AASI18006-GEC-V3-Signed.pdf Markup Summary

DESIGNED EJG	DRAWN KRK	CHECKED EJG
SCALE (H): 1" = 80' SCALE (V):		SHEET NO. 207
DATE: DECEMBER 20, 2018		
PROJECT NO. 096495003		
DWG. NAME 096495003_EC

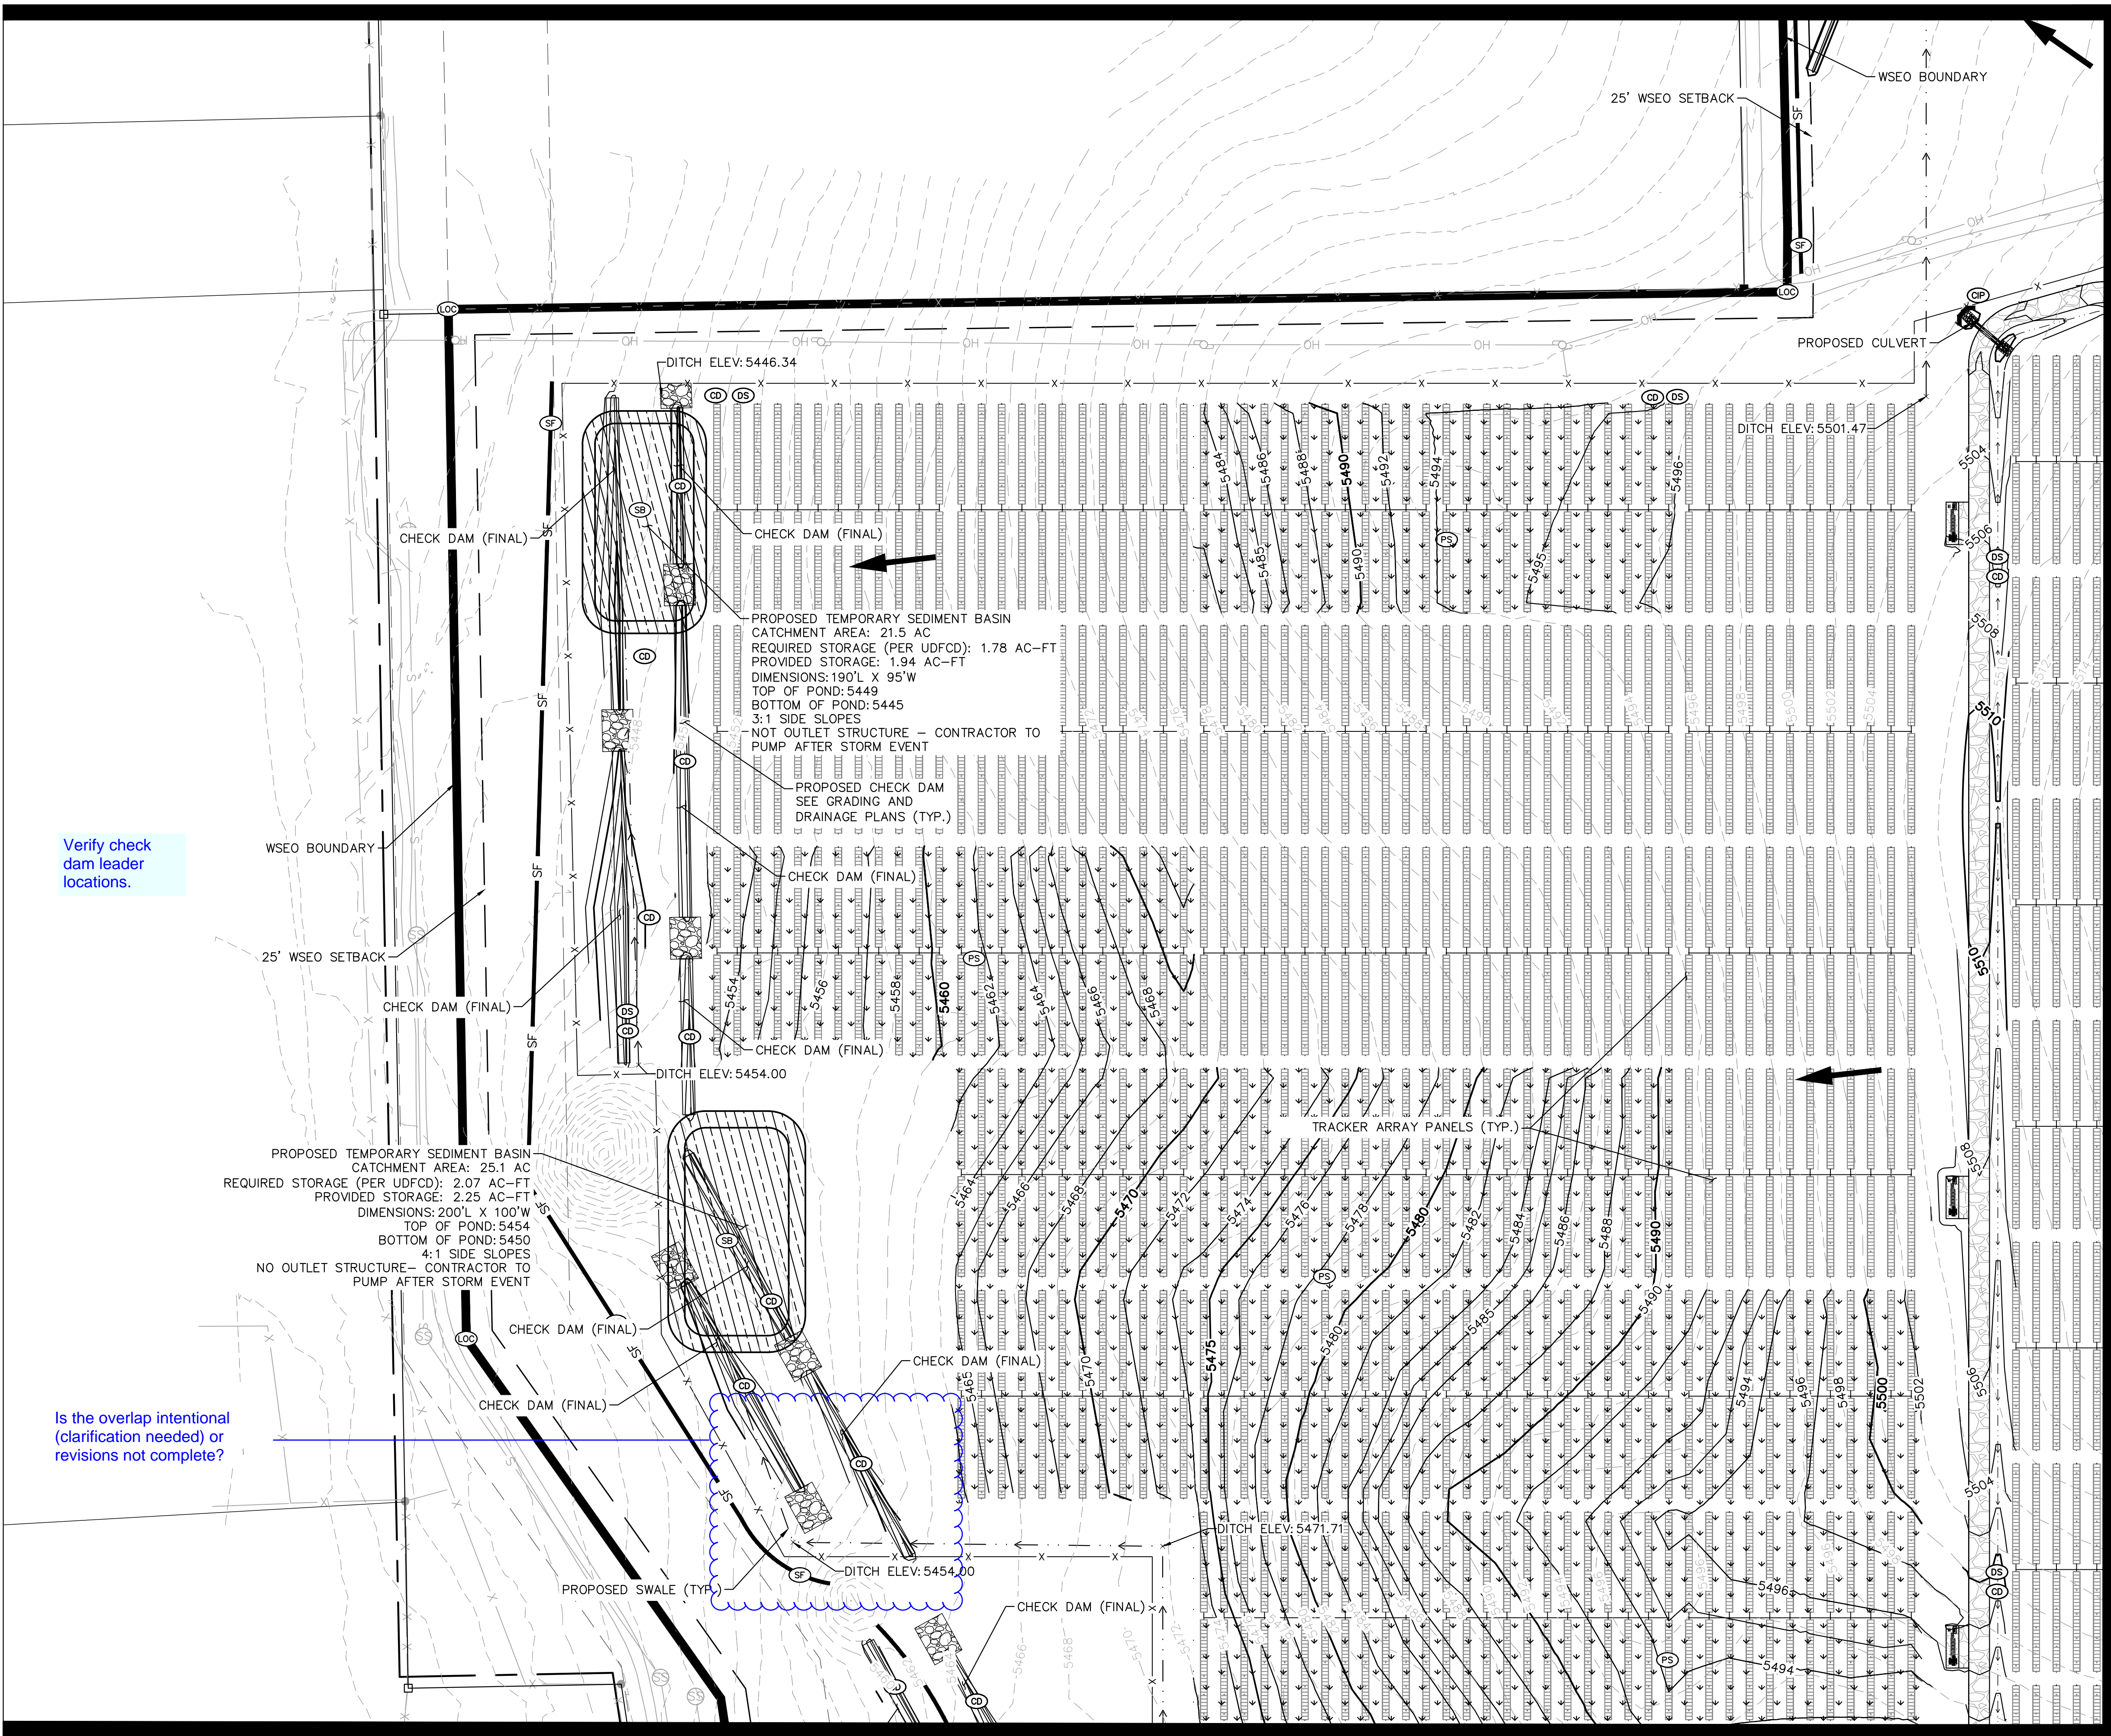
Call out check dams.

GRADING AND EROSION CONTROL PLAN-908 PLAN SUBMITTAL

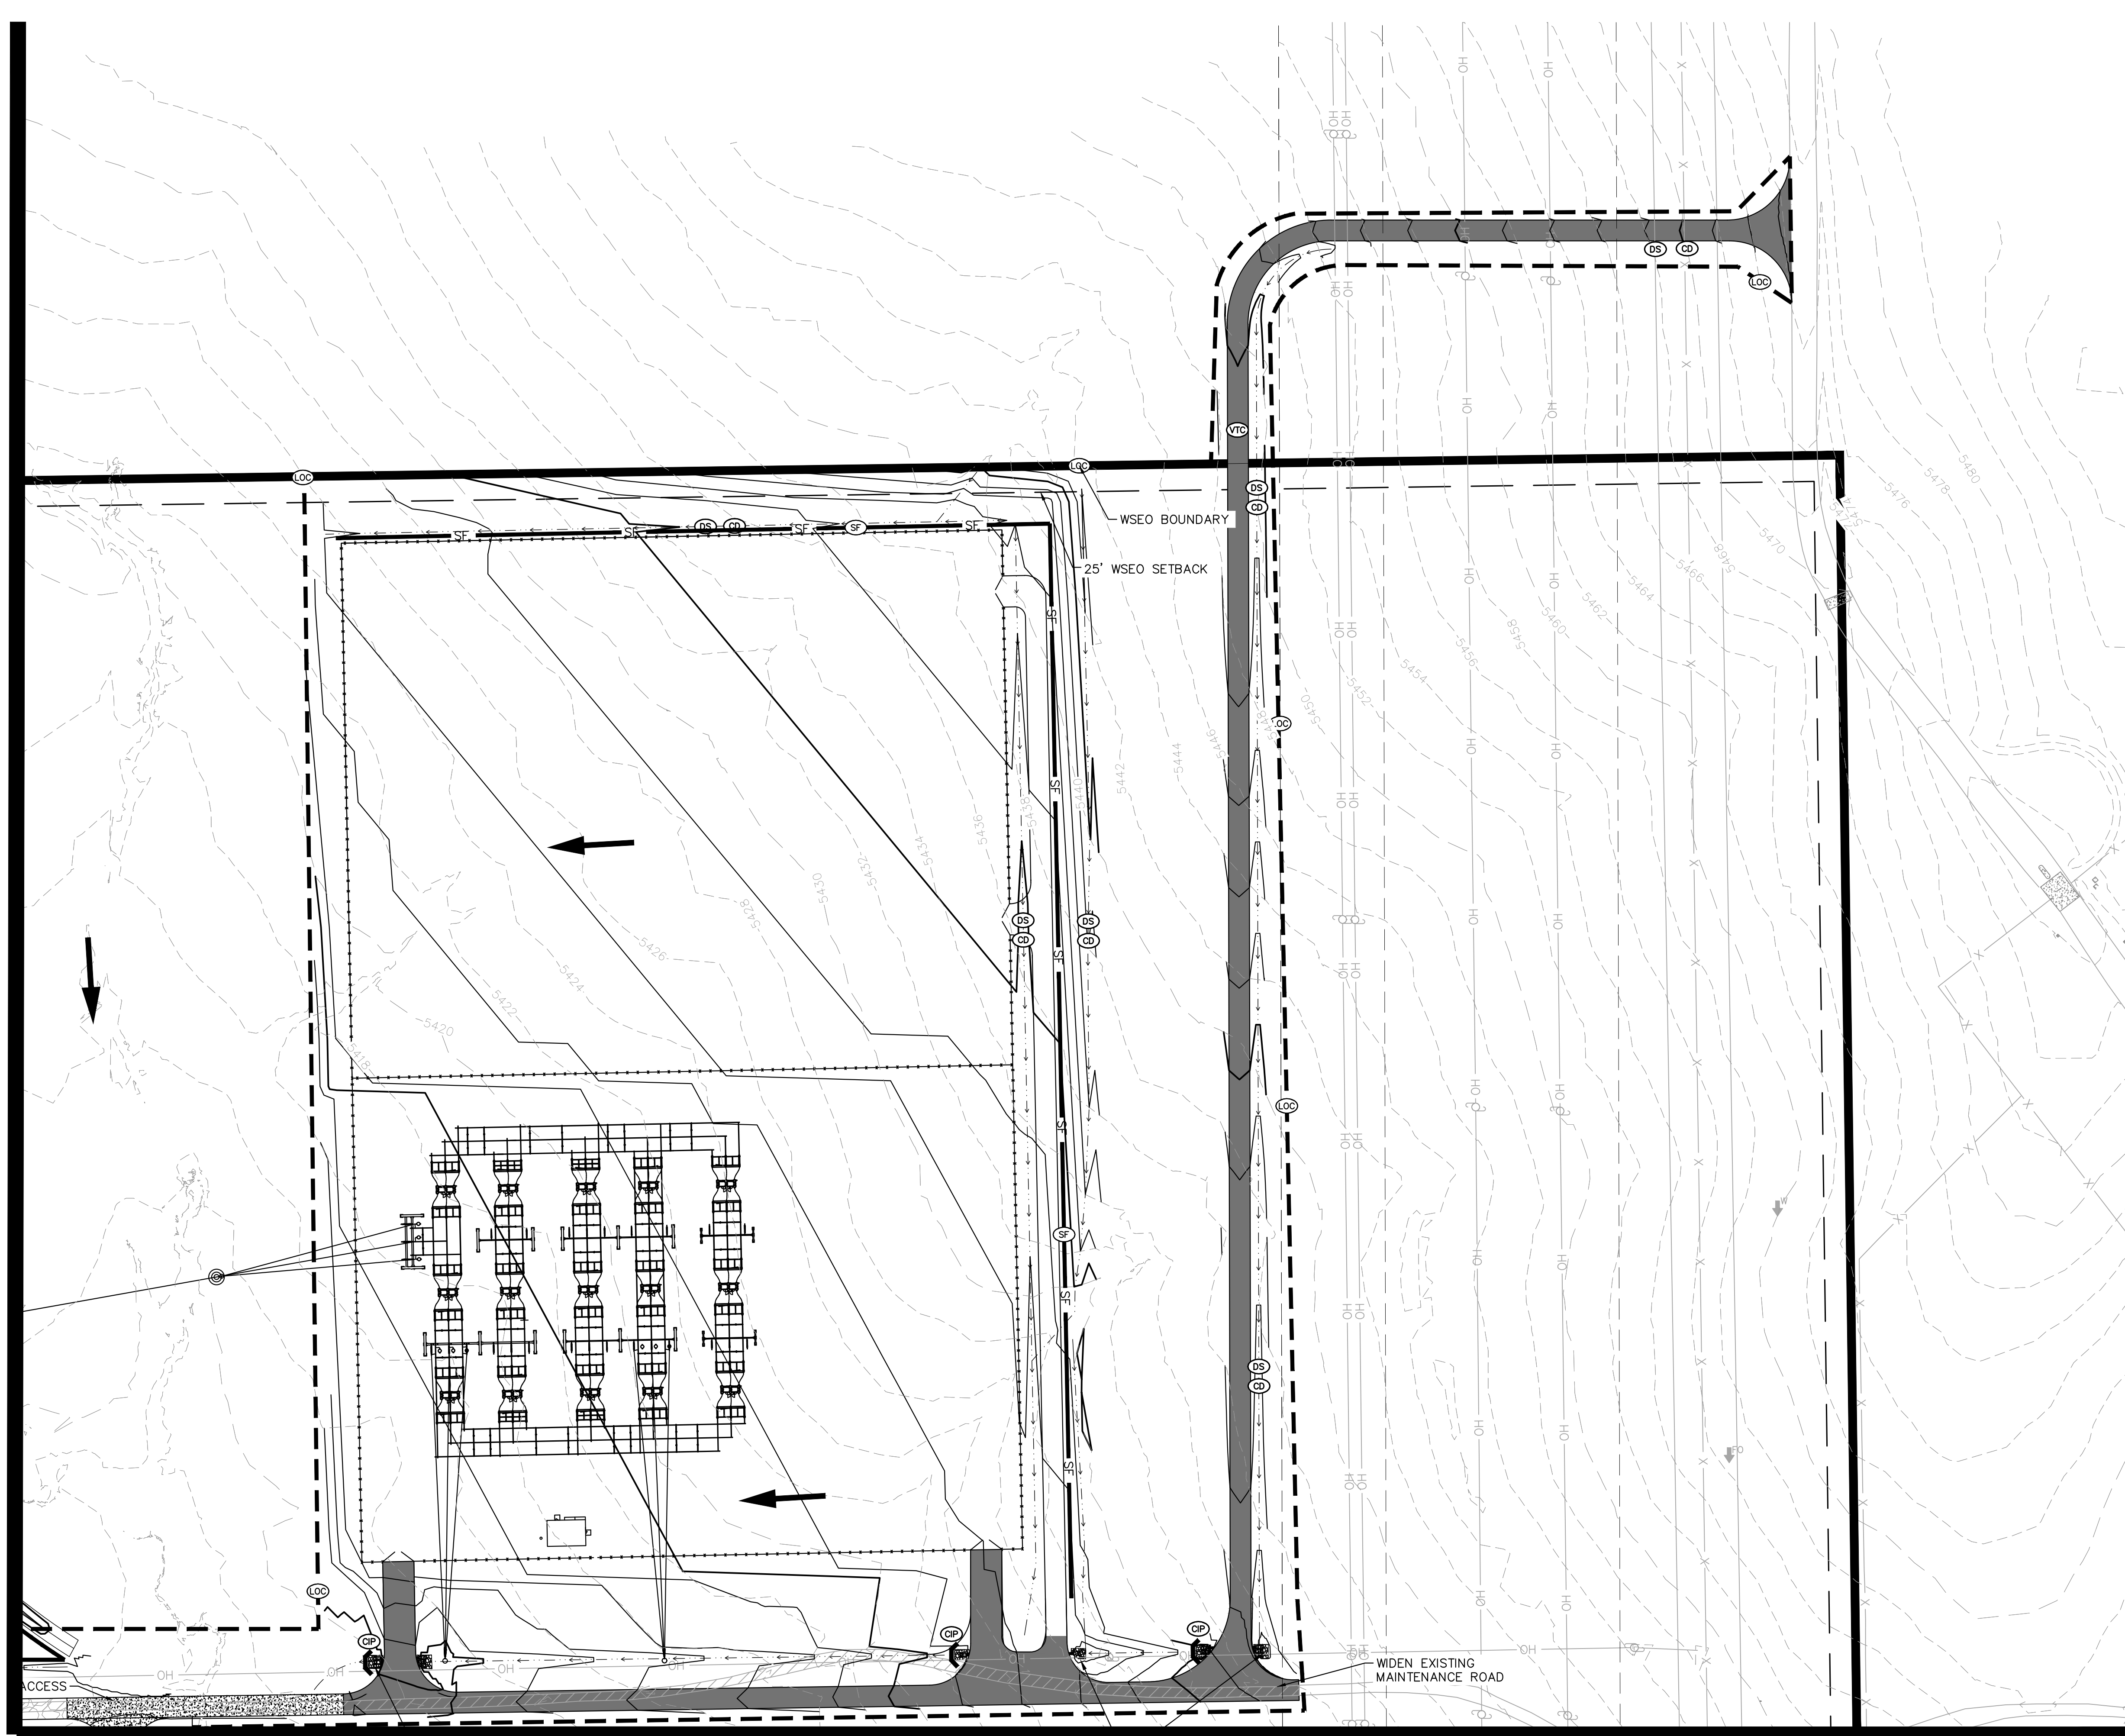
Call out the if this is a channel, if so label it. also call out a detail of the channel that is being proposed, like the size of the rip rap along the sides and end etc. recommendt that there is a typical section called out as well.
